Report of the Head of Planning, Sport and Green Spaces

Address 6 PRINCES PARK CIRCLE HAYES

Development: Erection of a single storey rear extension, which would extend beyond the rear wall of the original house by 4 metres, for which the maximum height would be 3 metres, and for which the height of the eaves would be 2.989 metres

LBH Ref Nos: 71418/APP/2016/863

Drawing Status			
PLANNING			
Designed by	ASJ	Checked by	Project No
Drawn by	ASJ	Date	Nov 15
Scales	1:100@A3 work to figured dimensions only	Drawing No	SL(0)20
			Revision B

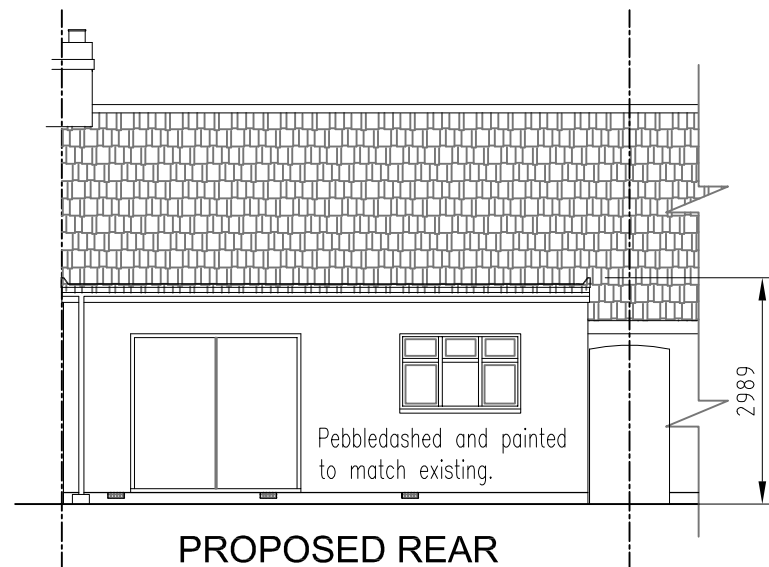
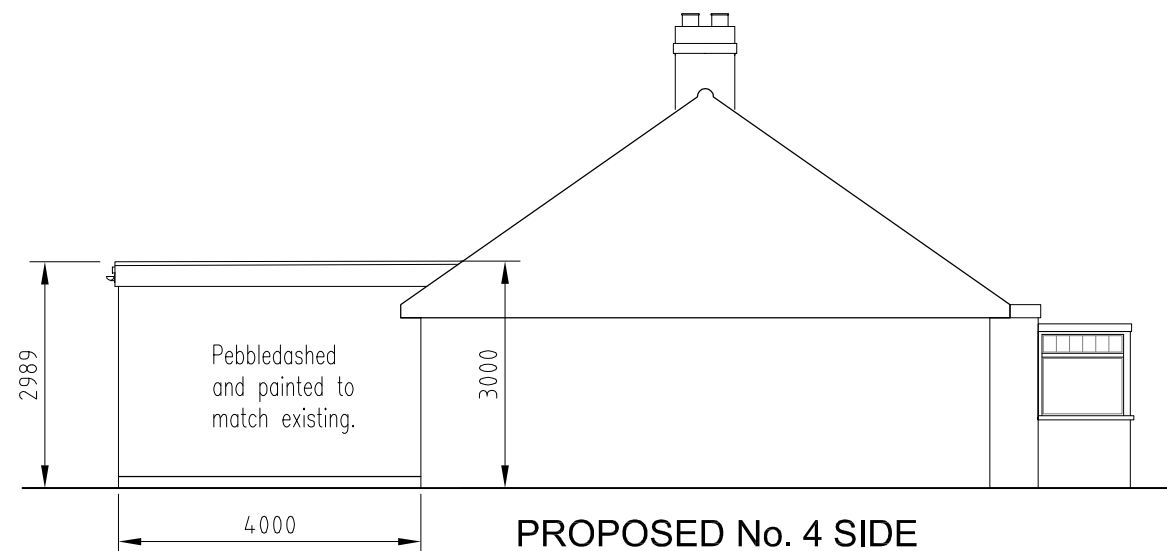
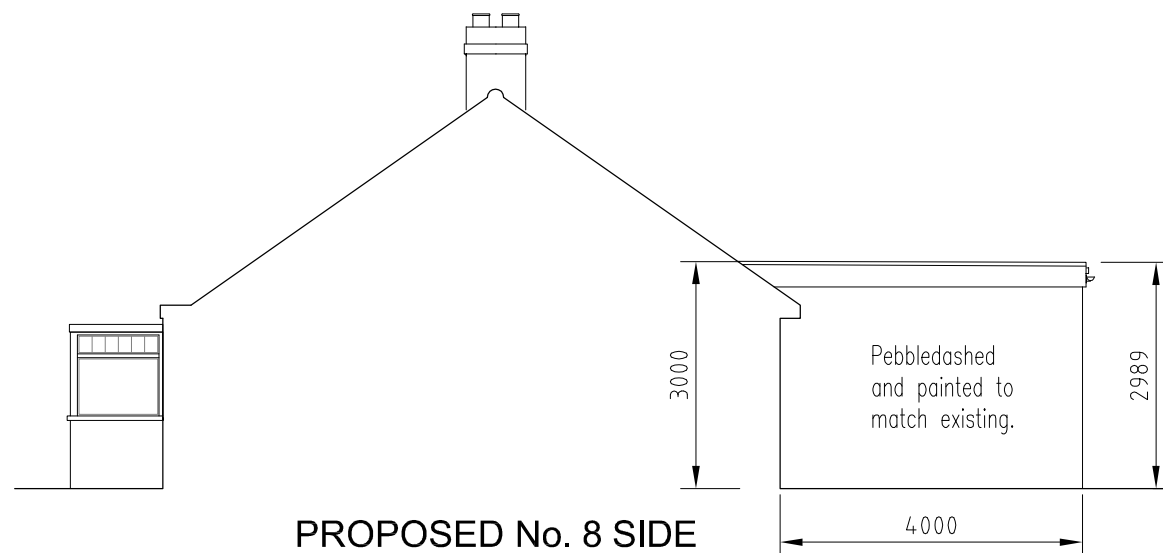
The proposed development does not constitute permitted development by virtue of the provisions of Schedule 2, Part 1, Class A of the Town and Country Planning (General Permitted Development) Order (2015), as submitted plans demonstrate that the height of the eaves of the part of the dwellinghouse to be enlarged would exceed the height of the eaves of the existing dwellinghouse.

Submitted plans do however demonstrate that the eaves height of the extension would be higher than the eaves of the original property. The proposed development therefore does not represent permitted development by virtue of the provisions of Schedule 2, Part 1, Class A of the Town and Country Planning (General Permitted Development) Order (2015).
